HINCKLEY RAIL FREIGHT TERMINAL

Comments on Written Submissions

CPRE Leicestershire

Oct 2023

Proposed Layout - Rigid Truck

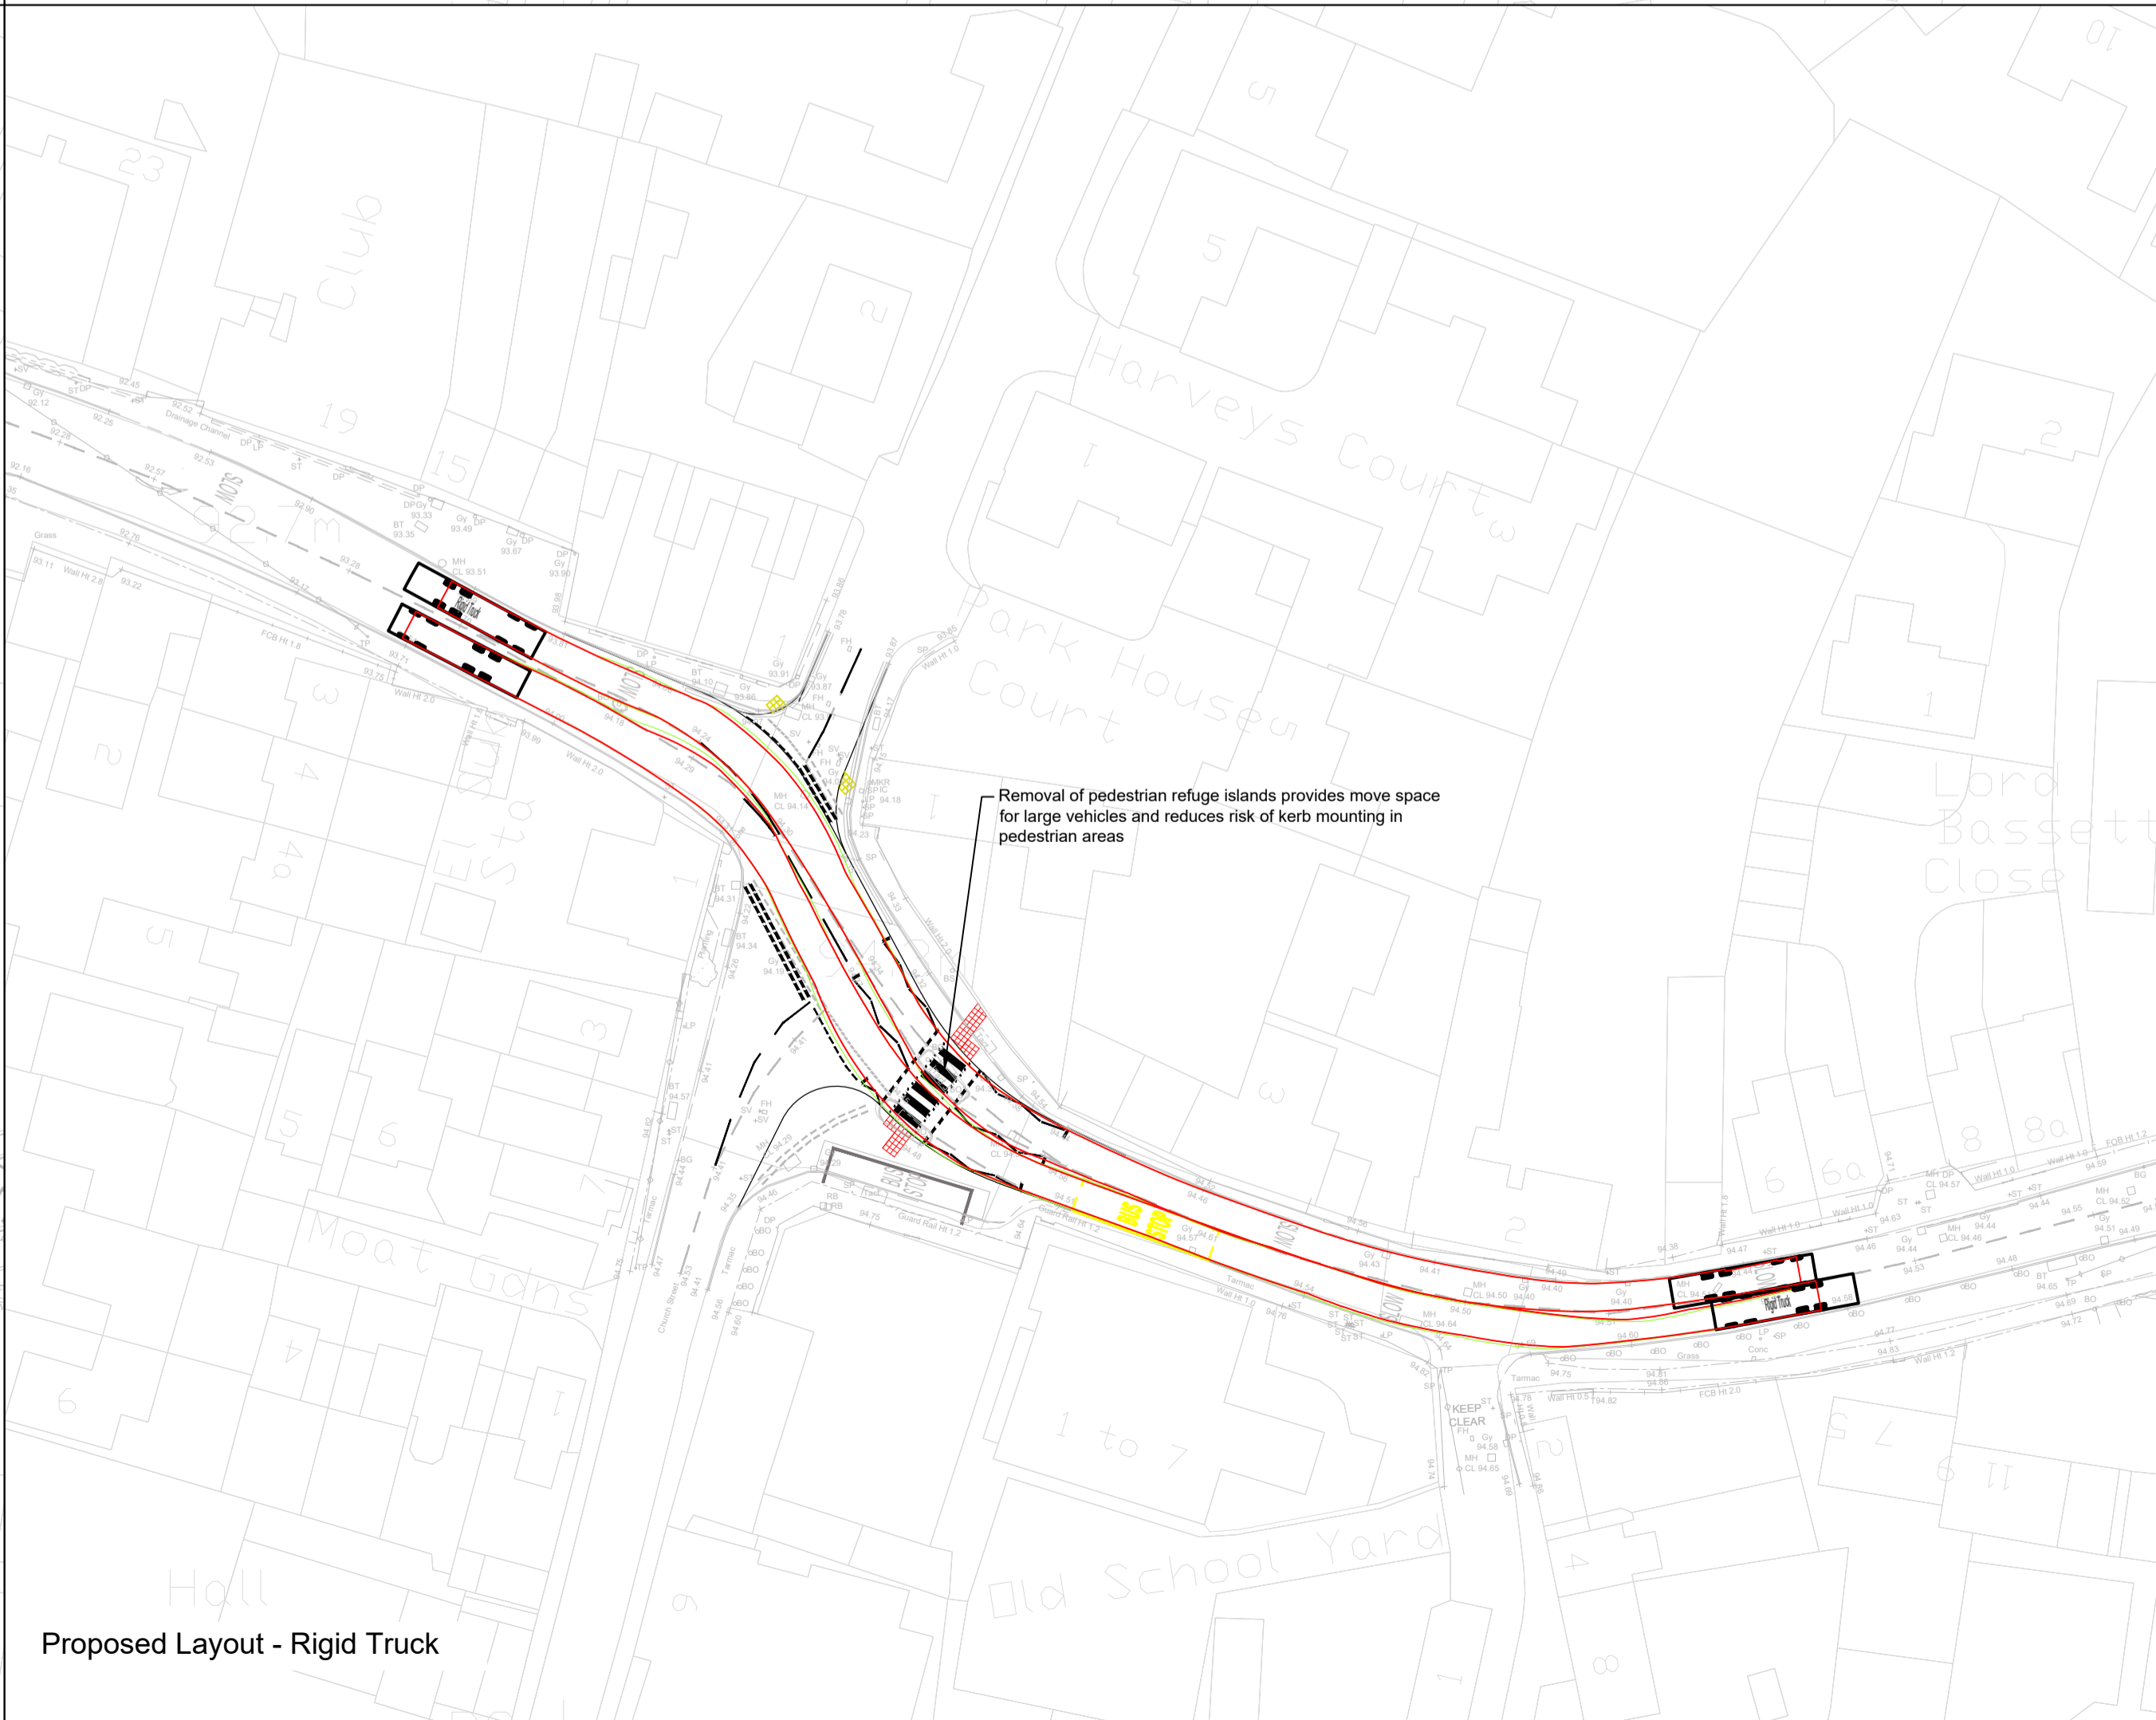
- 2.27 no vehicle tracking provided for HGVs
- 2.39 collision data from 2015-2019
- 2.44 furnishing relies on 2017-2019 counts
- 2.51 lorry park movements not included
- 2.55 Padge Hall 20% more traffic on A5
- 2.67 modelling information provided to the TWG included details not in the submission.
- 2.68 no unconstrained development modelling
- 2.72 detailed select link information on Sapcote shown to TWG but not in submission. Assessment of village not provided
- 2.89 basic design information for off-site mitigation missing from submission
- 2.100 route strategy enforcement not discussed with HA.
- 2.116 construction traffic routing limited info
